CITY OF ALBUQUERQUE

December 16, 2016

**RE: Loids Collision Center
Grading and Drainage Plan
Engineer's Stamp Date 11-17-2016 (File:B18D010)**

Based upon the information provided in your submittal received 11-17-2016, the above referenced plan cannot be approved for ESC permit for grading and Building Permit until the following items are addressed:

CG-102

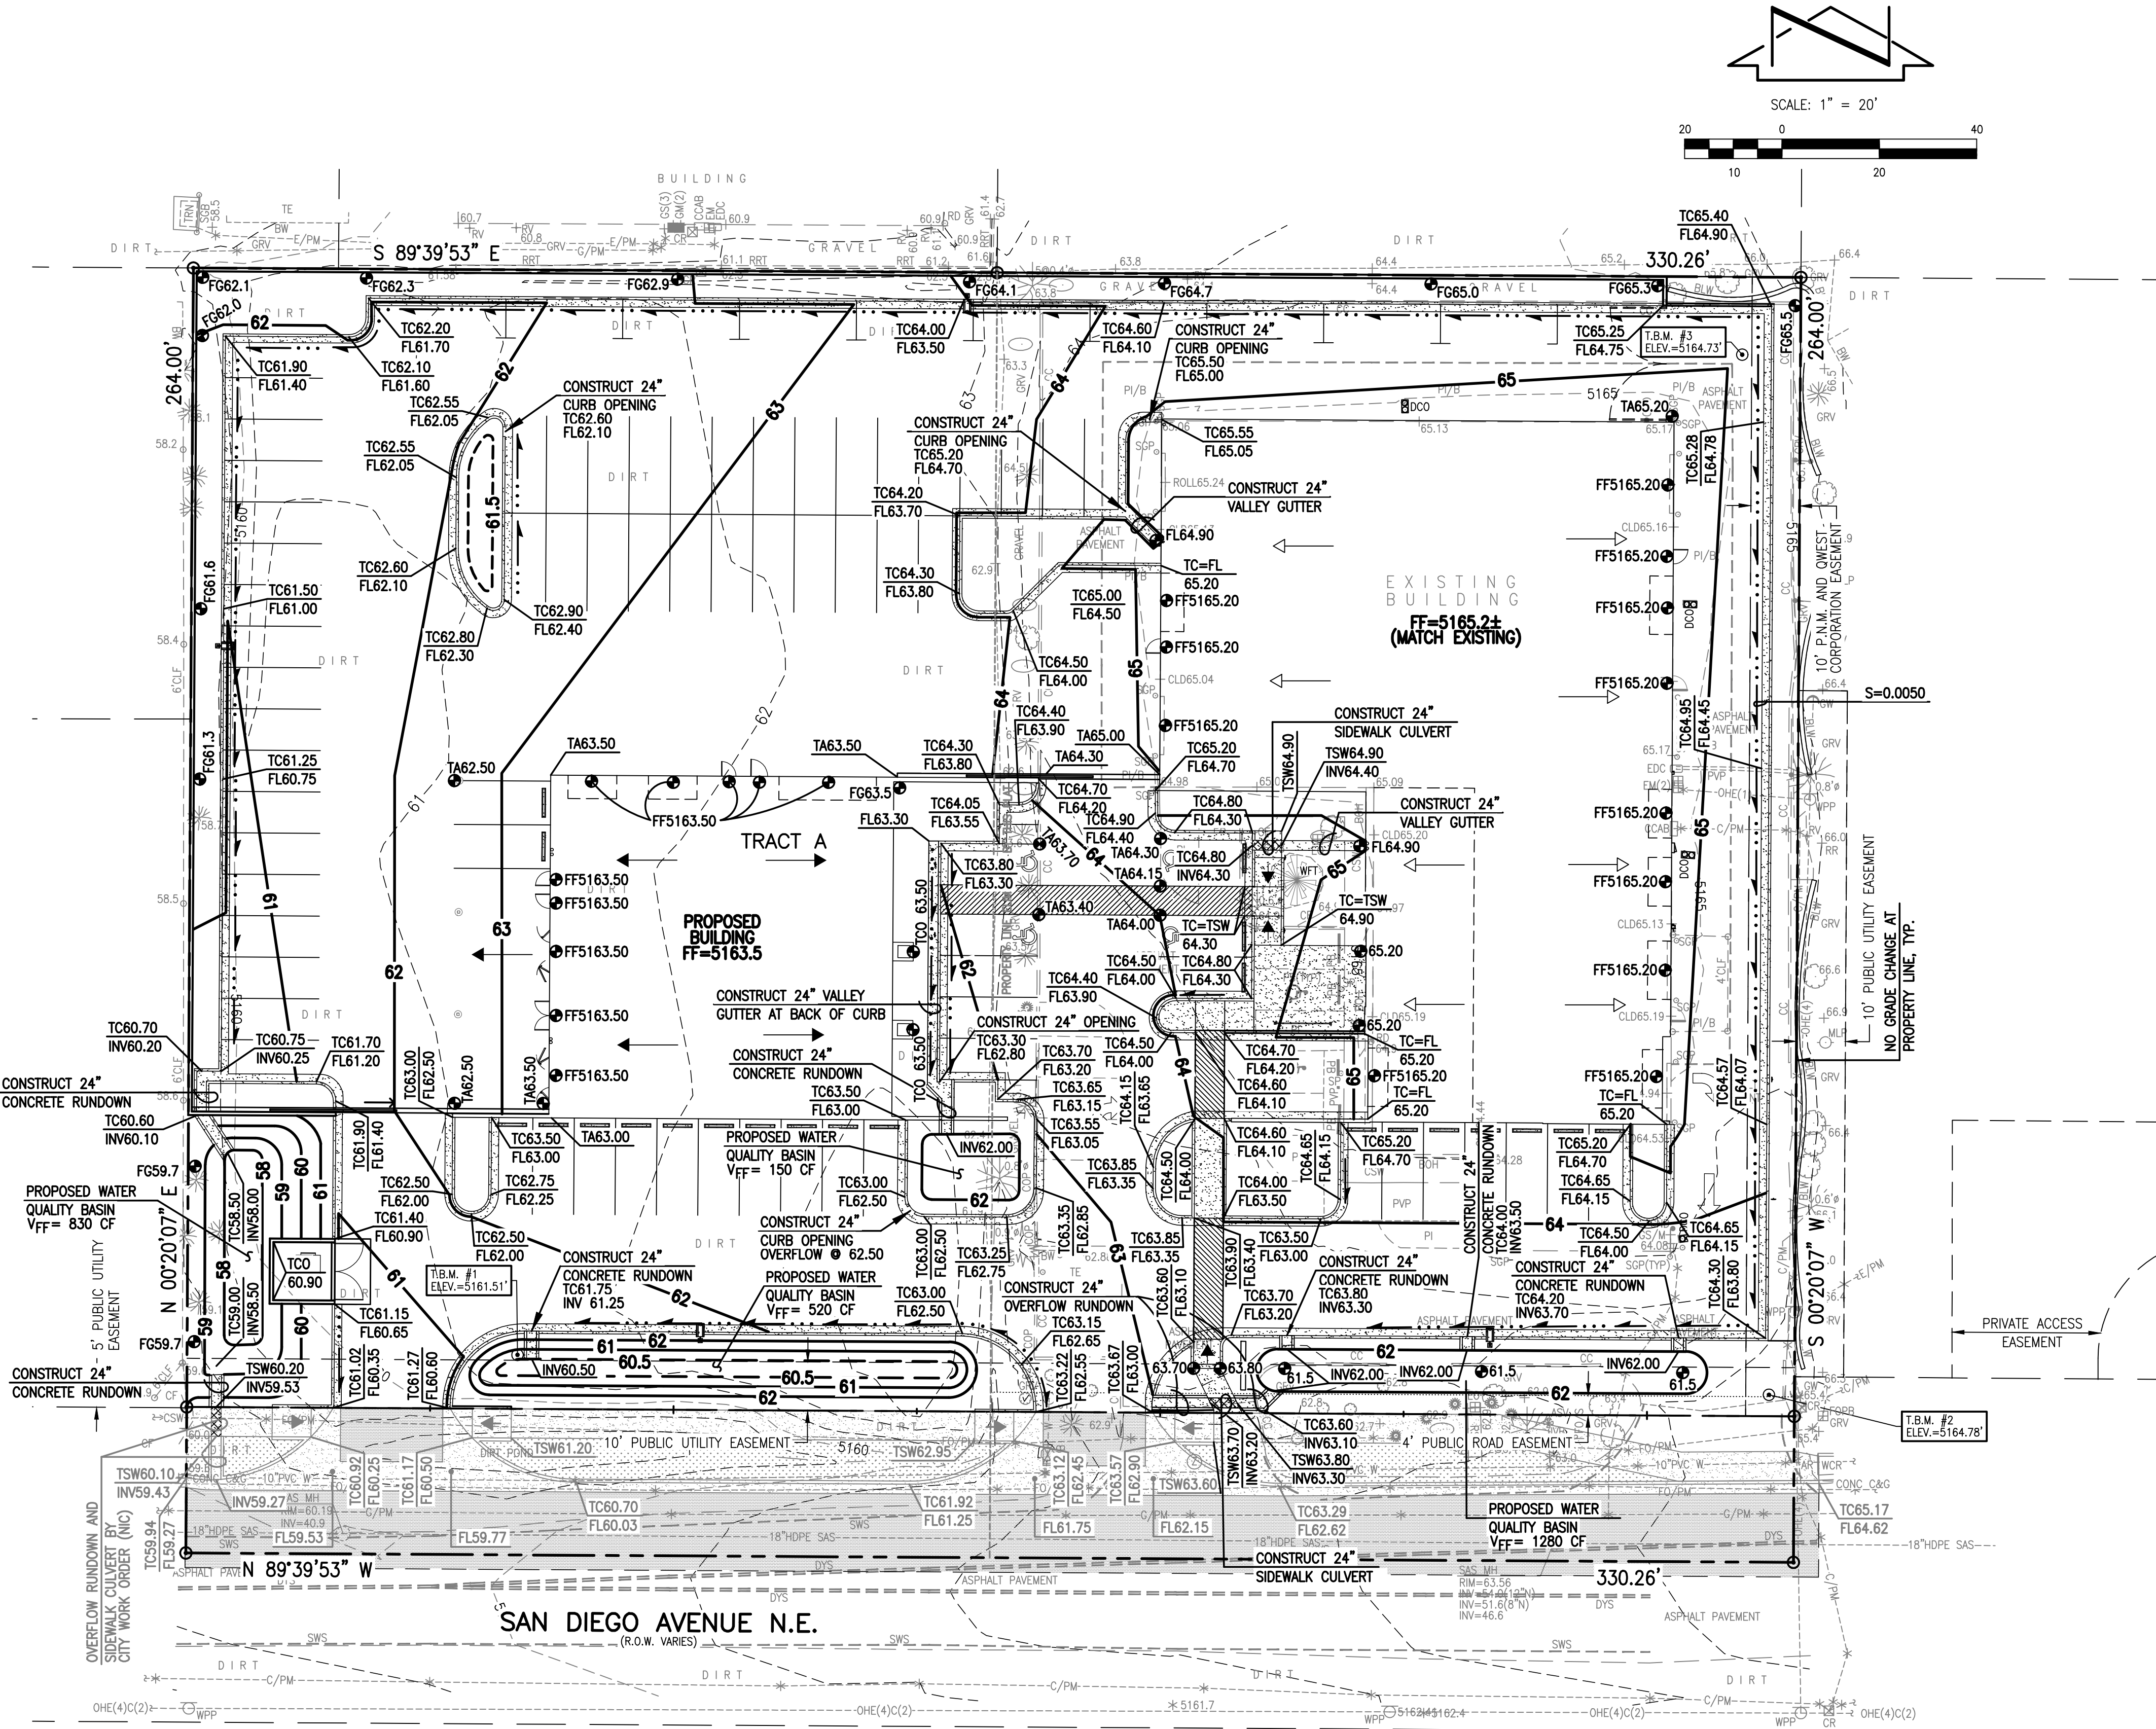
1. It appears a retaining wall is required along the western edge, since there is a grade change greater than 2 feet.
2. The 63 contour is mislabeled as a 62 contour in the middle of the site.
3. The project has one outfall for the 100-yr storm, so one basin is appropriate. However, the project has three outfalls for stormwater quality. Do you think it is appropriate to delineate basins for sizing storm water quality ponds?
